Adams School Redevelopment

Addendum No. 4 to Contract Documents

April 12, 2012

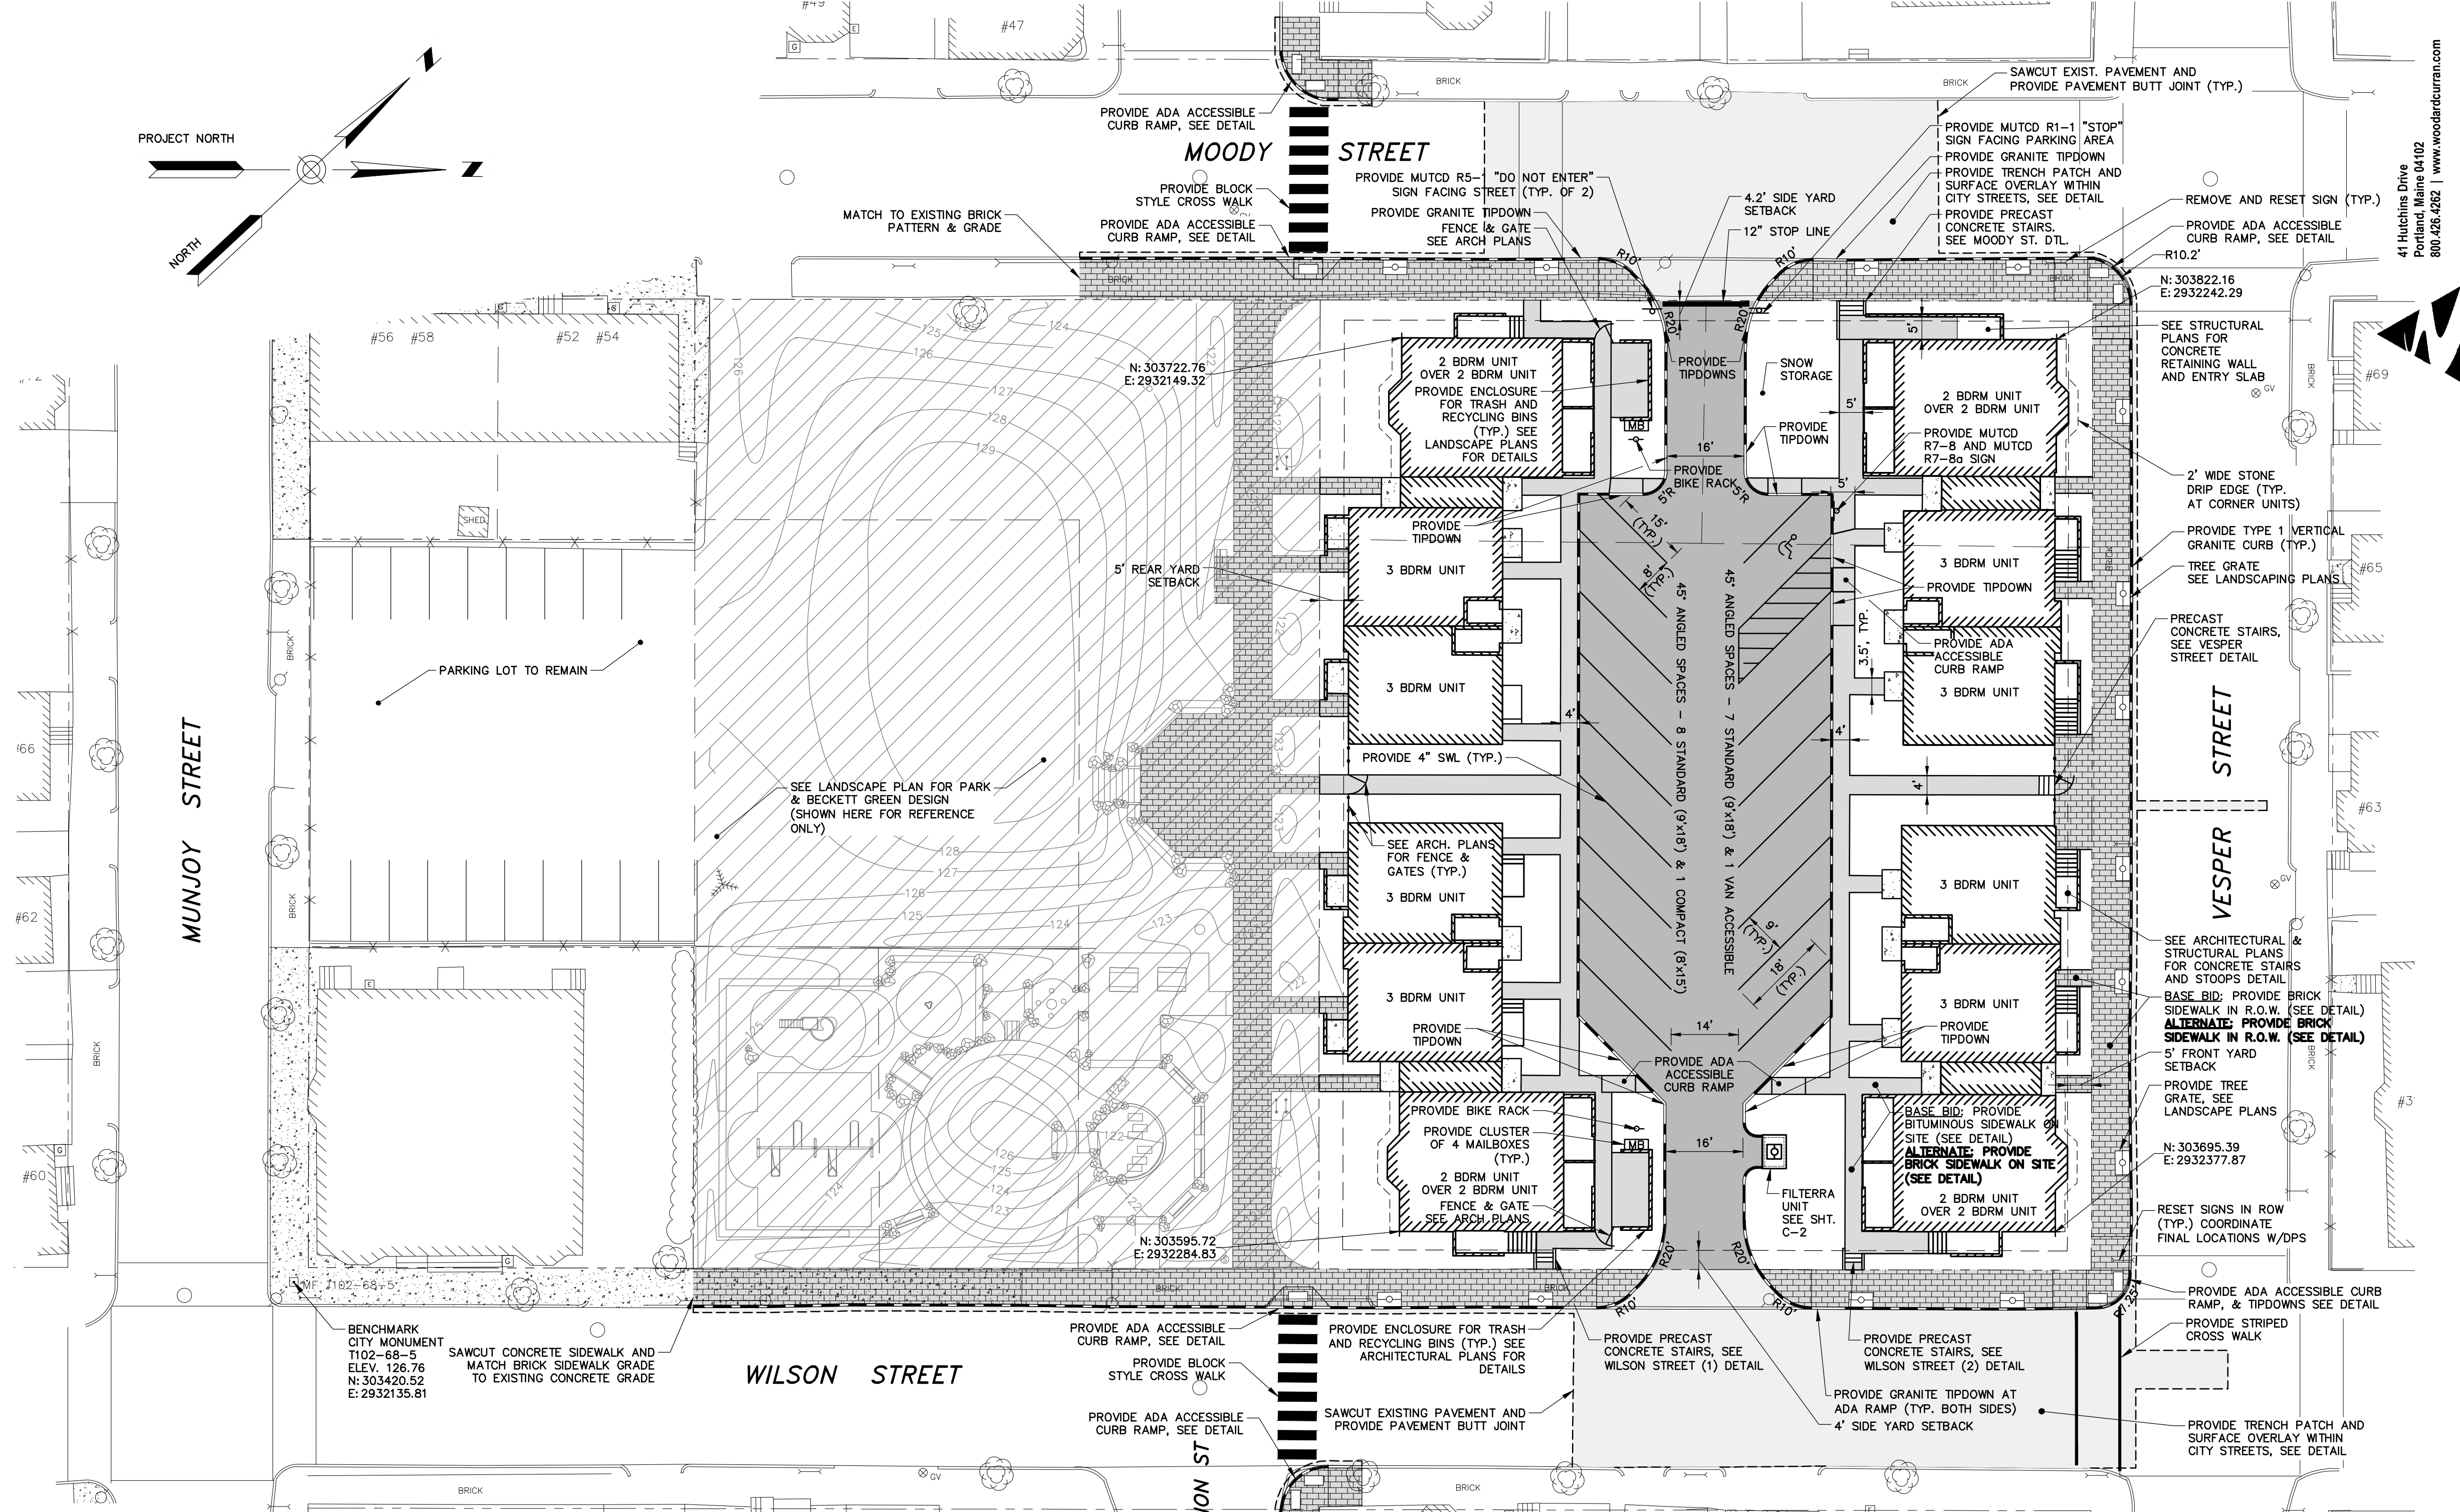
- A. SHEET C-2: Modify as shown on attached SK-1 and SK-2.
